SADDLEHORN RANCH - FILING NO. 2

GRADING AND EROSION CONTROL PLANS

EPC STORMWATER REVIEW COMMENTS ARE SHOWN IN ORANGE BOXES WITH BLACK TEXT

PCD Project Number: SF-21-033

SHEET 6 OF 14

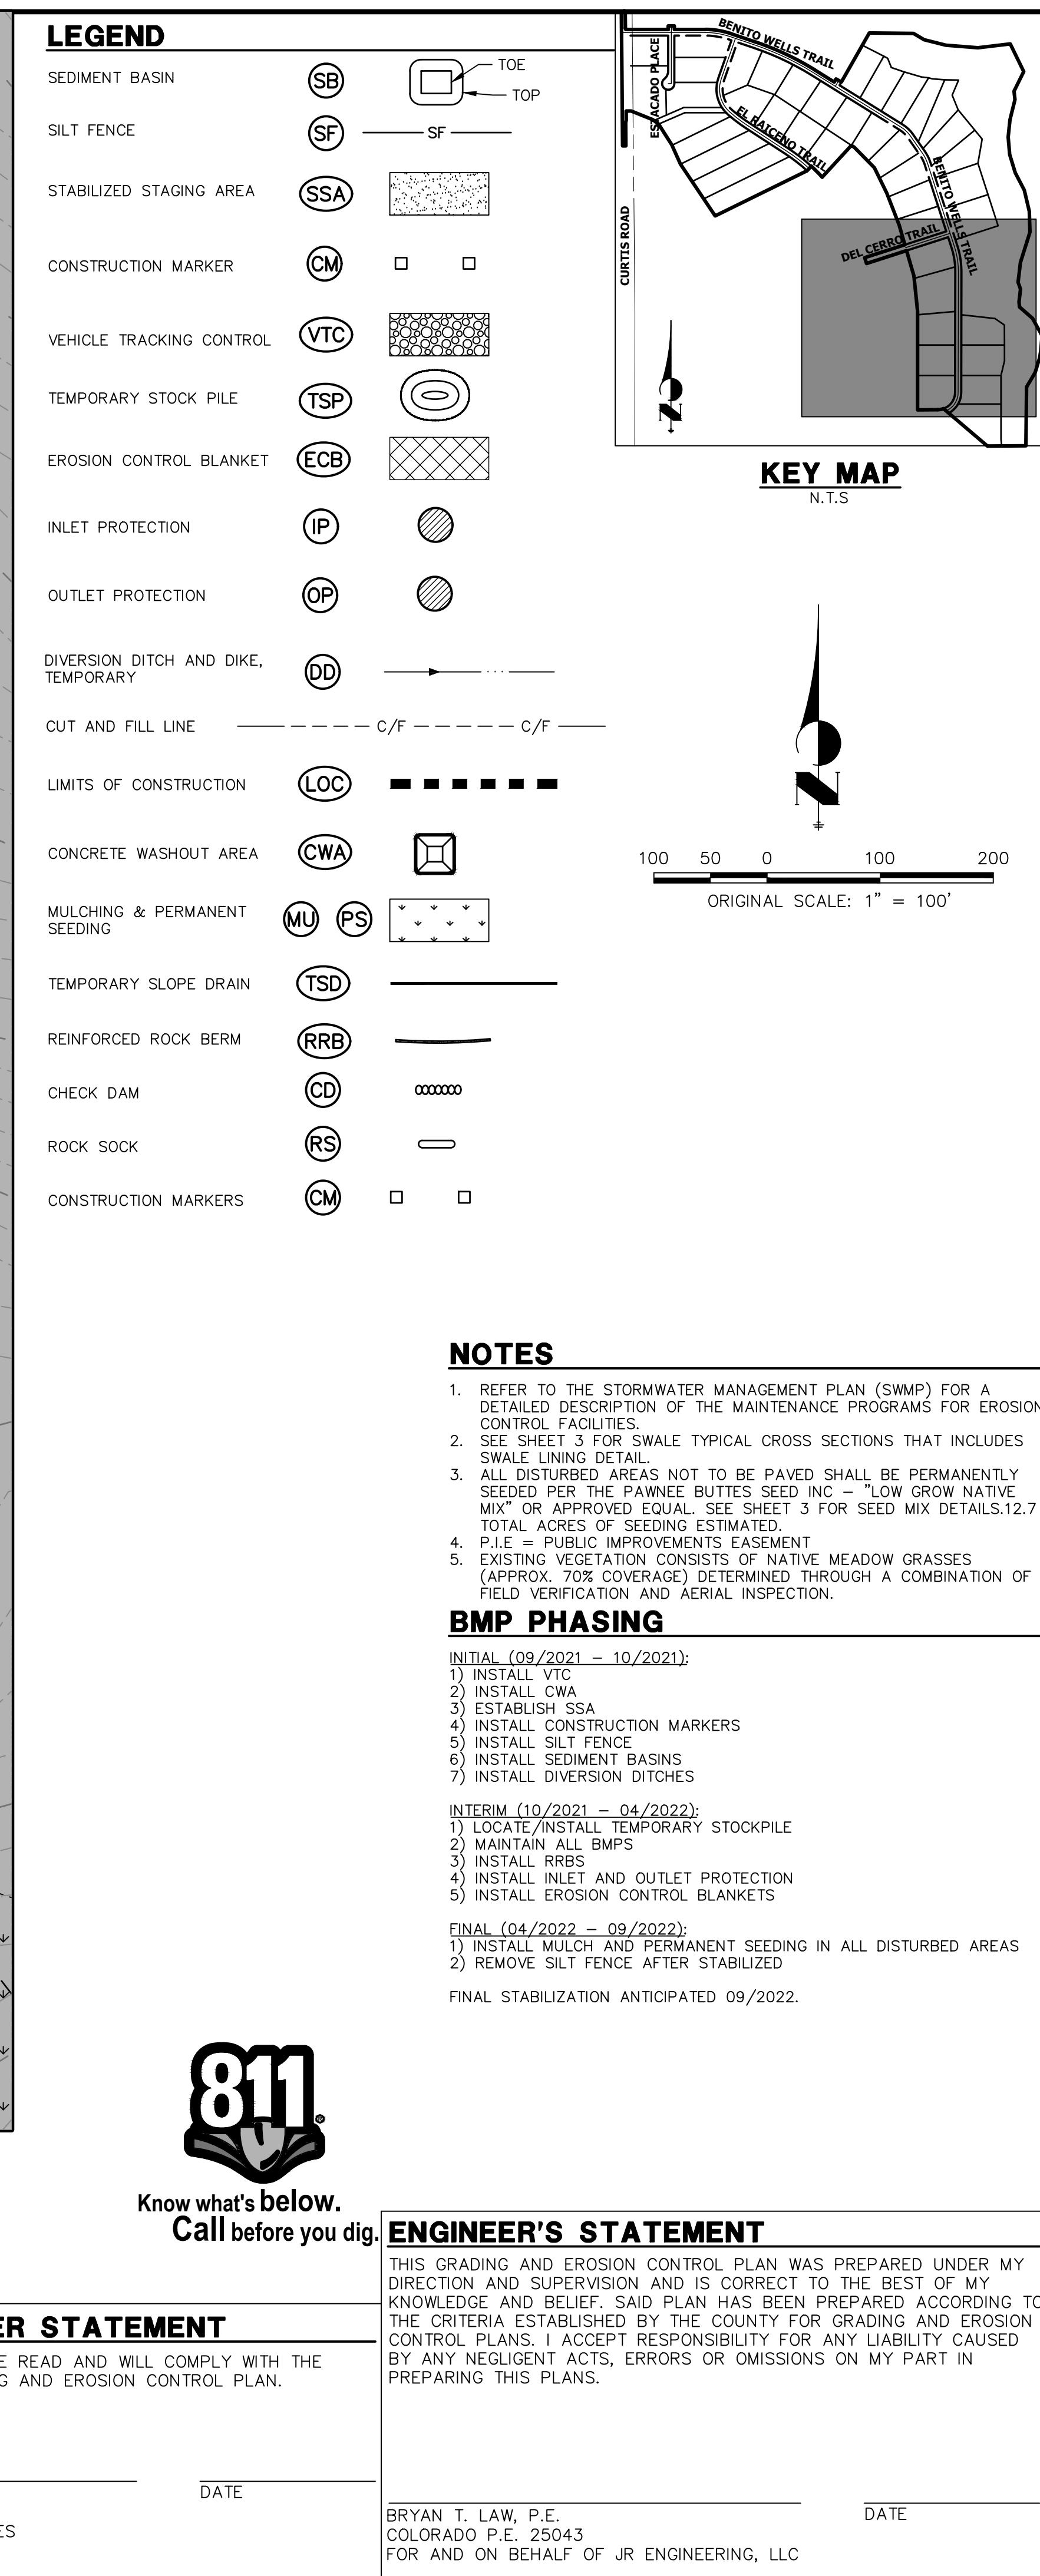
Are these TSBs already existing or will they be installed during the initial phase? If they have not been installed yet, provide details of temporary sediment basin including riser pipe perforation sizing, number of rows, required volume, location of outlet and spillway, and tributary area to the sediment basin. (you can name the two basins and then circle the corresponding details on Tables SB-1 and SB-2 - Sheet 8)
